**KIRKLEES METROPOLITAN COUNCIL  
INVESTMENT & REGENERATION SERVICE**

**DELEGATED DECISION TO DETERMINE PLANNING APPLICATIONS**

**Reference No:** 2019/62/93712/W  
**Site Address:** land off, Coniston Road, Meltham, Holmfirth, HD9 4BY  
**Description:** Erection of stables and formation of access track  
**Recommending Officer:** Ellie Worth

CLIENT			
MR NIGEL DYSON			
PROJECT			
PROPOSED STABLE BLOCK CALMLANDS MELTHAM			
DRAWING TITLE			
PROPOSED SITE PLAN			
Rev.	Notes	Date	Drawn
A	PLANNING	01.20	A.D.
B	PLANNING	01.20	A.D.
SCALE			
1:200@A1		11.19	A.D.
PROJECT No.		DRAWING No.	Rev.
1971		01	B

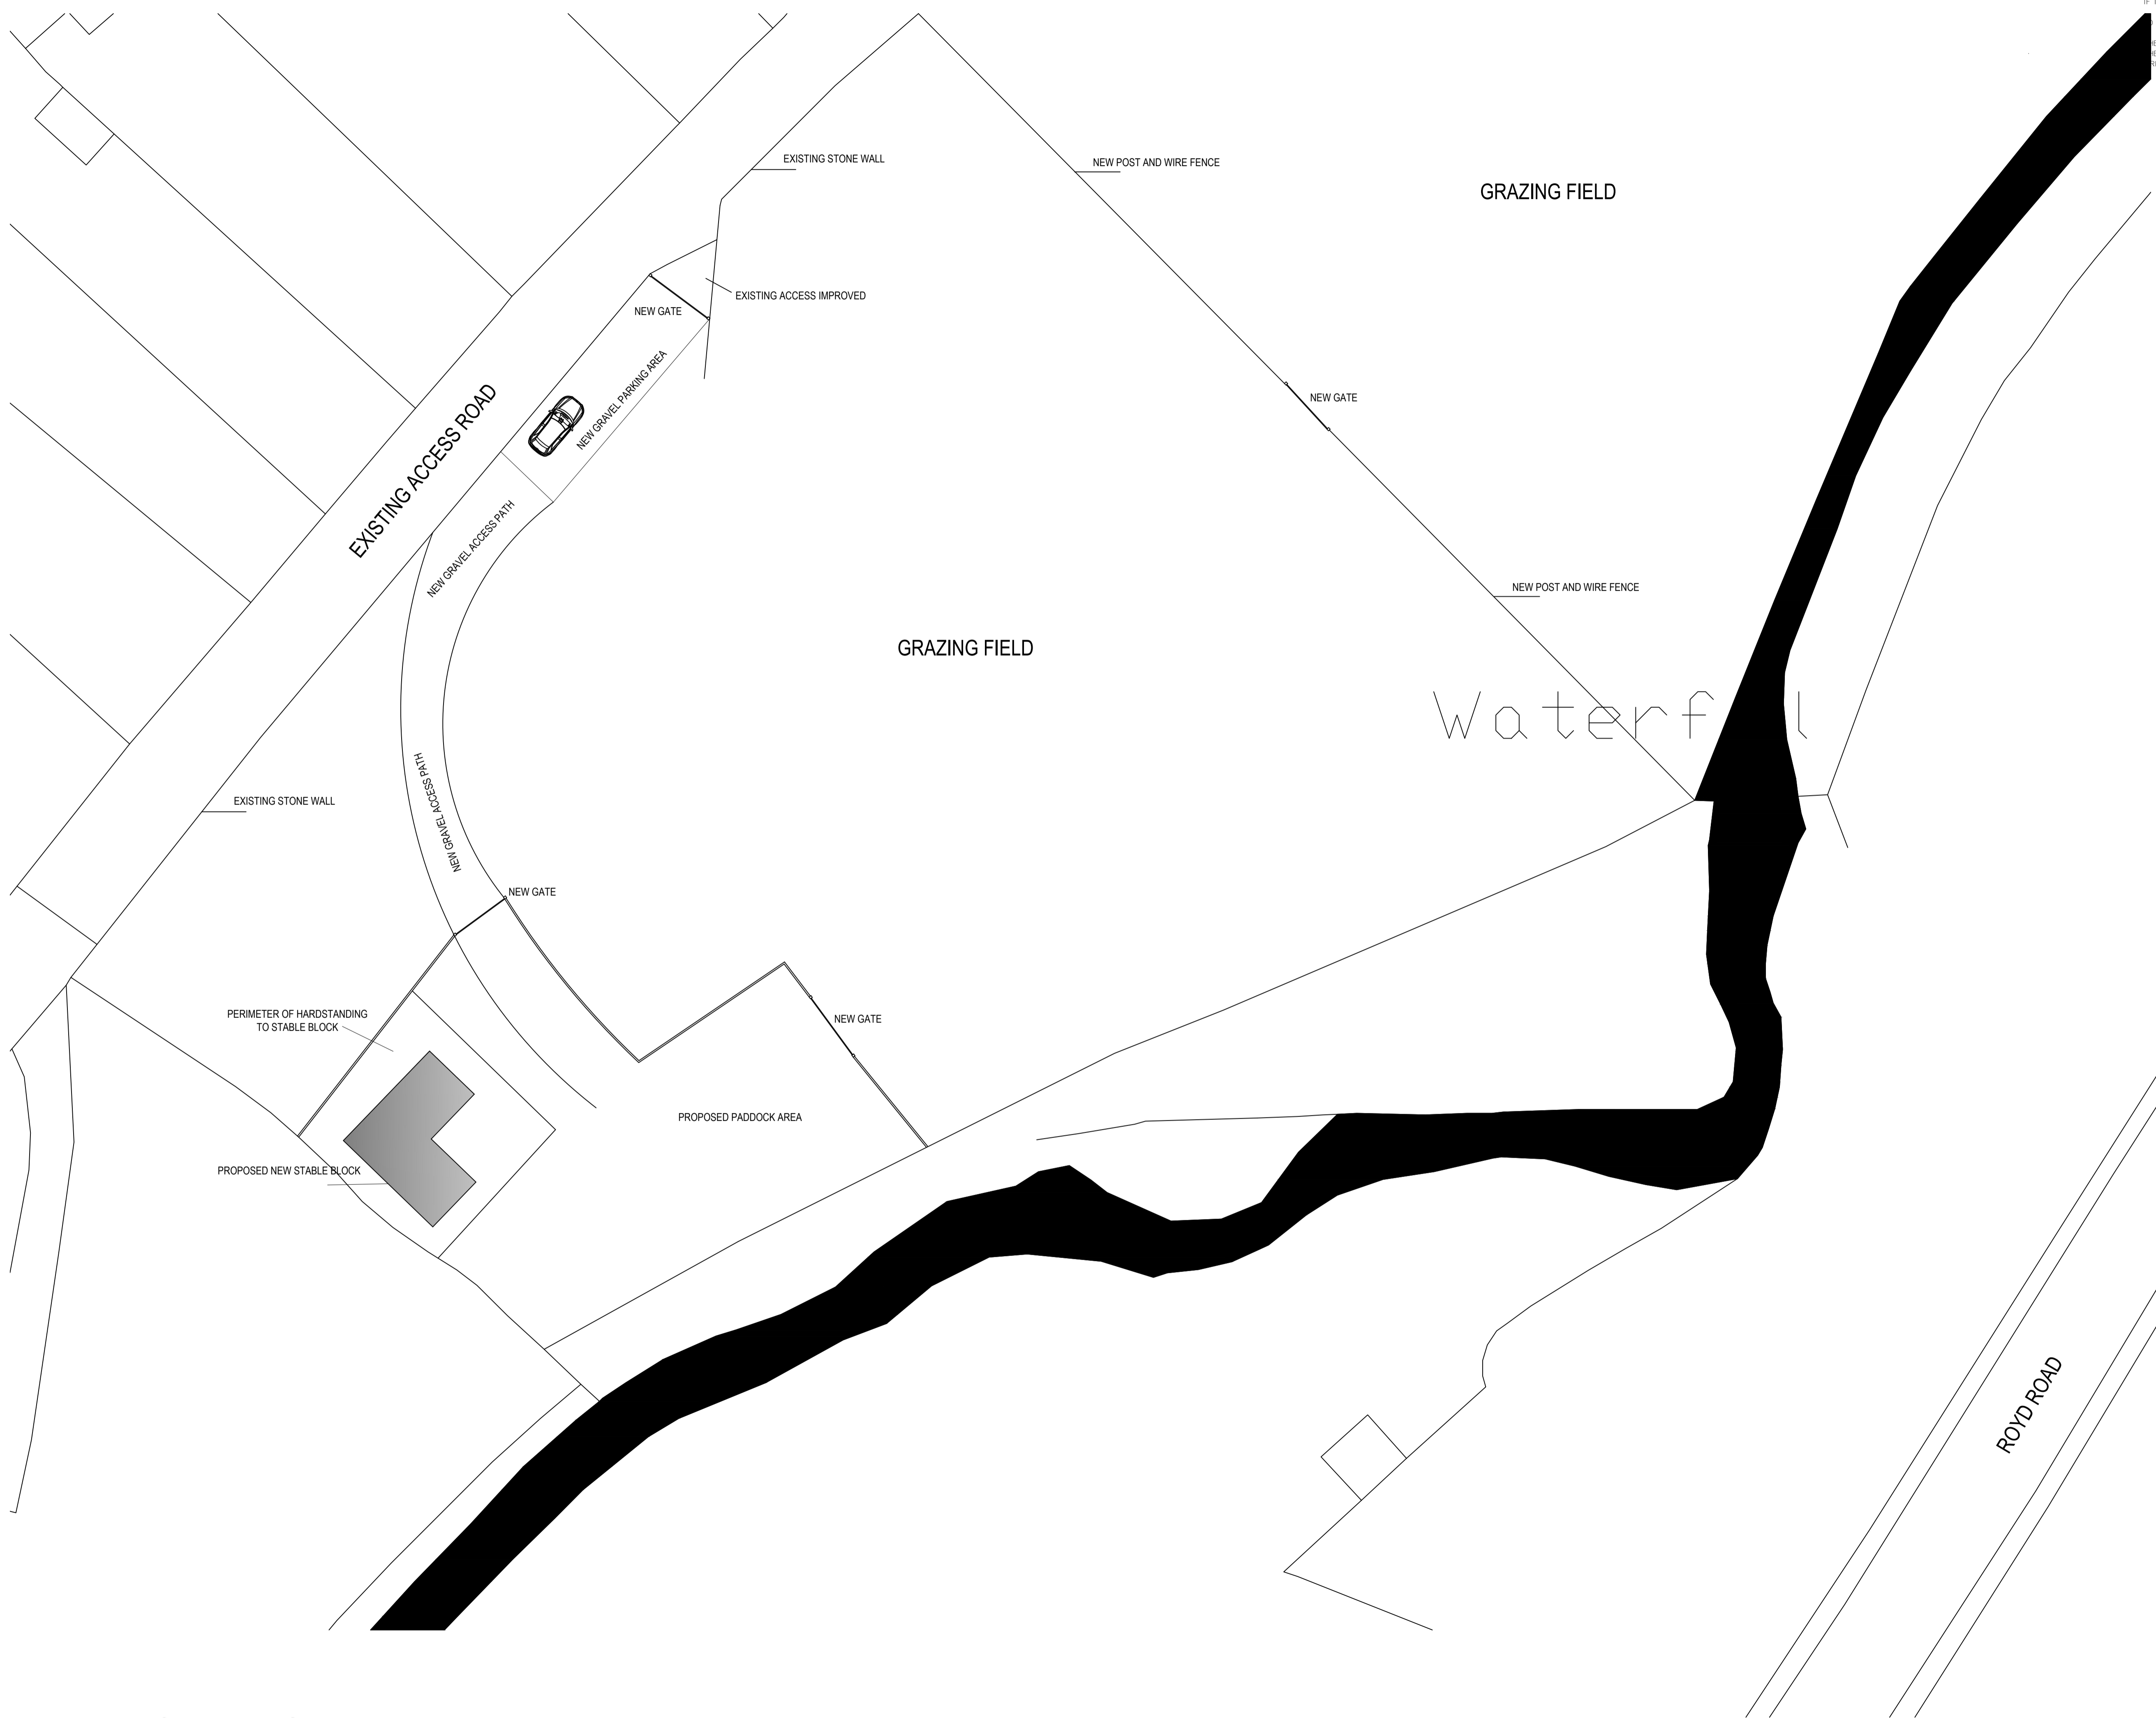
With regards to access, initial concerns were raised with the agent regarding the scale of these works. As such, an amended plan has been received reducing the area of hardstanding to the North West of the Site. This will now provide an area which would be 15m in length by 4.7m in width to allow for

two cars or a larger vehicle to enter the site and would be surfaced in gravel. The submitted plans also show a new gravelled access track to be provided down to the stables themselves. The new access is considered to represent an engineering operation and as set out in paragraph 146 of the NPPF would not represent inappropriate development in the Green Belt provided they preserve openness and do not conflict with the purposes of including land within the Green Belt.

Whilst there would be some visual impact from the new access it is considered to be proportionate to the scale of development and would be positioned adjacent to the existing access track, and would not appear as an uncommon feature within the rural landscape. The area of the access would remain predominately open and the proposal would therefore not adversely impact on openness and given its limited scale, use associated with the scale block and gravel finish is not considered to lead to any detrimental encroachment into the countryside most relevant purpose of the Green Belt in this instance. The proposal is therefore considered to have an acceptable impact on the Green Belt and visual amenity would be adequately protected, in accordance with Policies LP24 and LP56 of the Kirklees Local Plan.

It is also reasonable to impose another condition to ensure the access track and parking area are appropriately surfaced and drained. It is noted that gravel is to be used which would be acceptable but the condition will ensure that this area is provided and would ensure that surface water run-off is reduced. This would accord with Policies LP28 and LP34 of the Local Plan.

4. Prior to the development being first brought into use, the approved vehicle parking areas as shown on the hereby approved site plan dwg no. 01 Rev B shall be provided and surfaced and drained in accordance with the
